**Consultation Response from KC,
Lead Local Flood Authority****2024/91316 Clough House, 236, Leeds Road, Birstall, Batley, WF17 0HW****Conversion of existing dwelling and outbuilding to create 6 apartments and erection of 17 dwellings****Date Responded: 15/07/2024.****Responding Officer: Martin Stephenson****Responding Ref: 1****Documents reviewed by the LLFA:**

Acumen Architects:

- Drawing Ref: 2848 (100) 06, Proposed Site Layout, Rev A dated March 2024.
- Drawing Ref: 2848 (100) 01, Existing Site Layout, Rev - dated March 2024.

- Drawing Ref: E24/8177/01, Drainage Feasibility Plan, Rev A dated April 2024.

1 PROPOSED SITE LAYOUT  
1 : 500

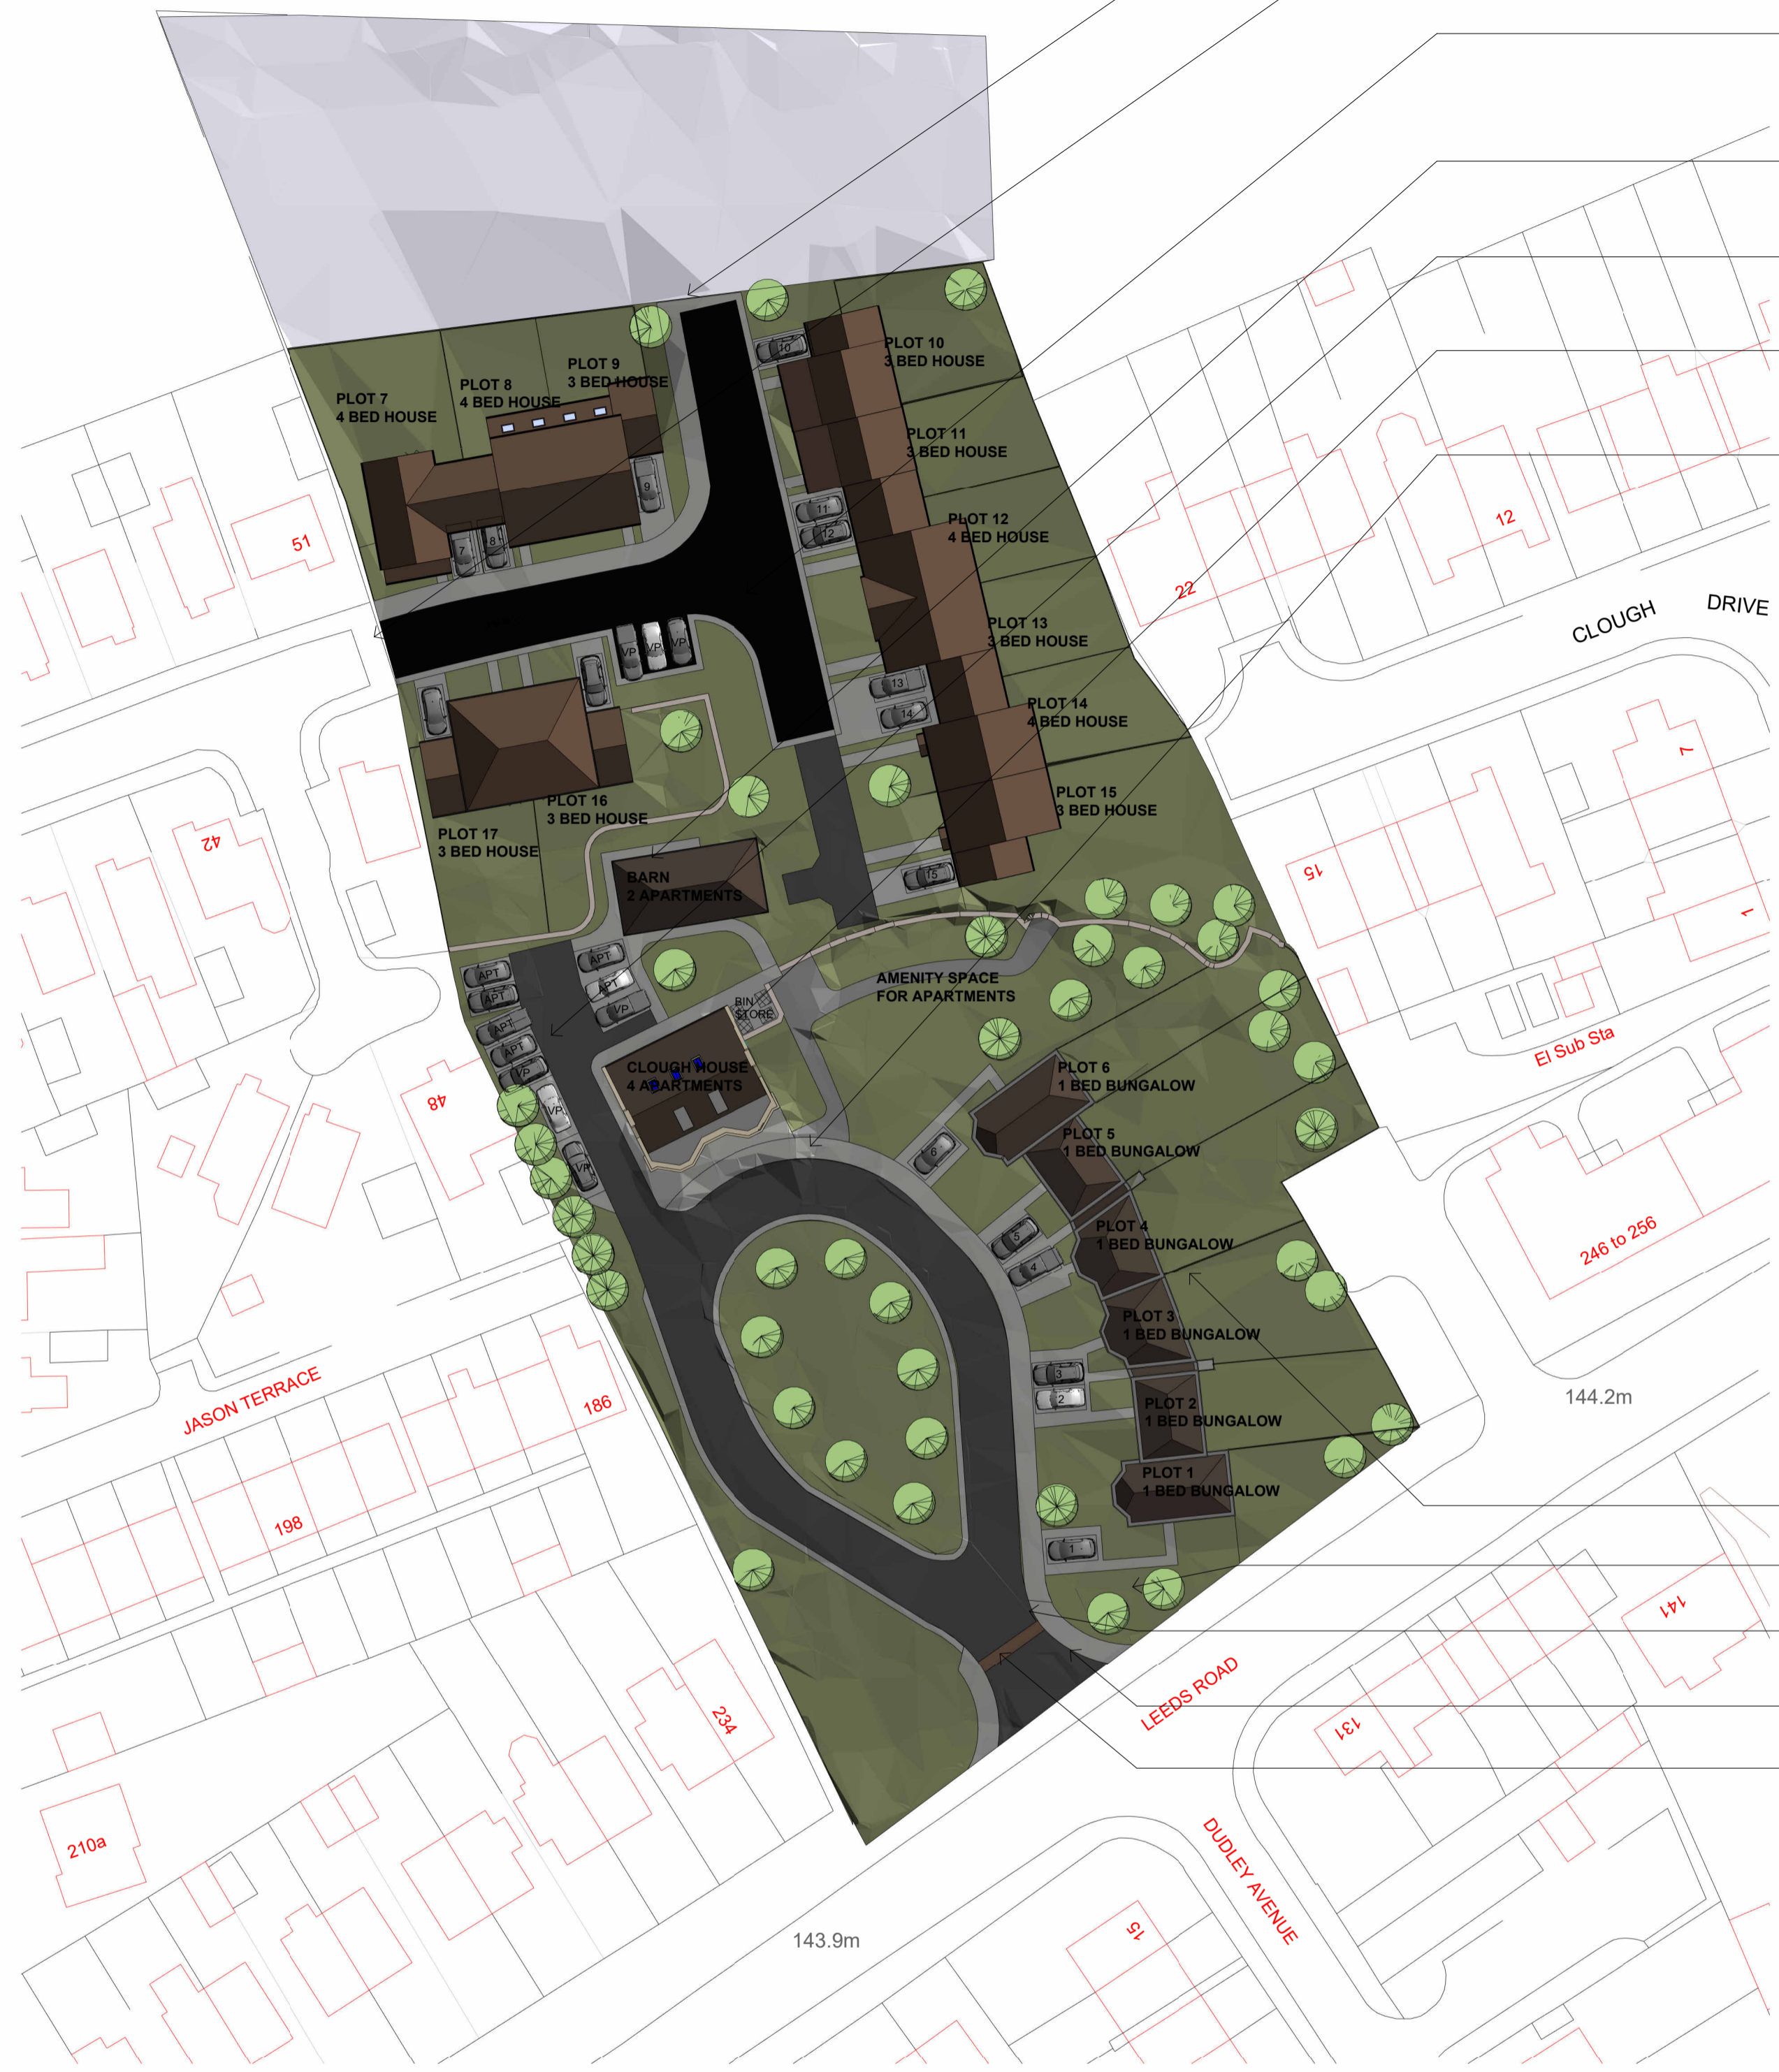
Kirklees Council's surface water data indicates that there is a risk of flooding up to 600mm depth in Pennine View on the northern boundary of the site during a surface water flooding event with a 1 in 100 year annual probability. Consideration should be given to the routing of floodwater from outside the site than crosses the boundary from this or other sources into the development. A plan indicating the route of any flood water, whether caused by surface water flows entering the site, blockages or flows greater than the design storm, should be submitted for approval.
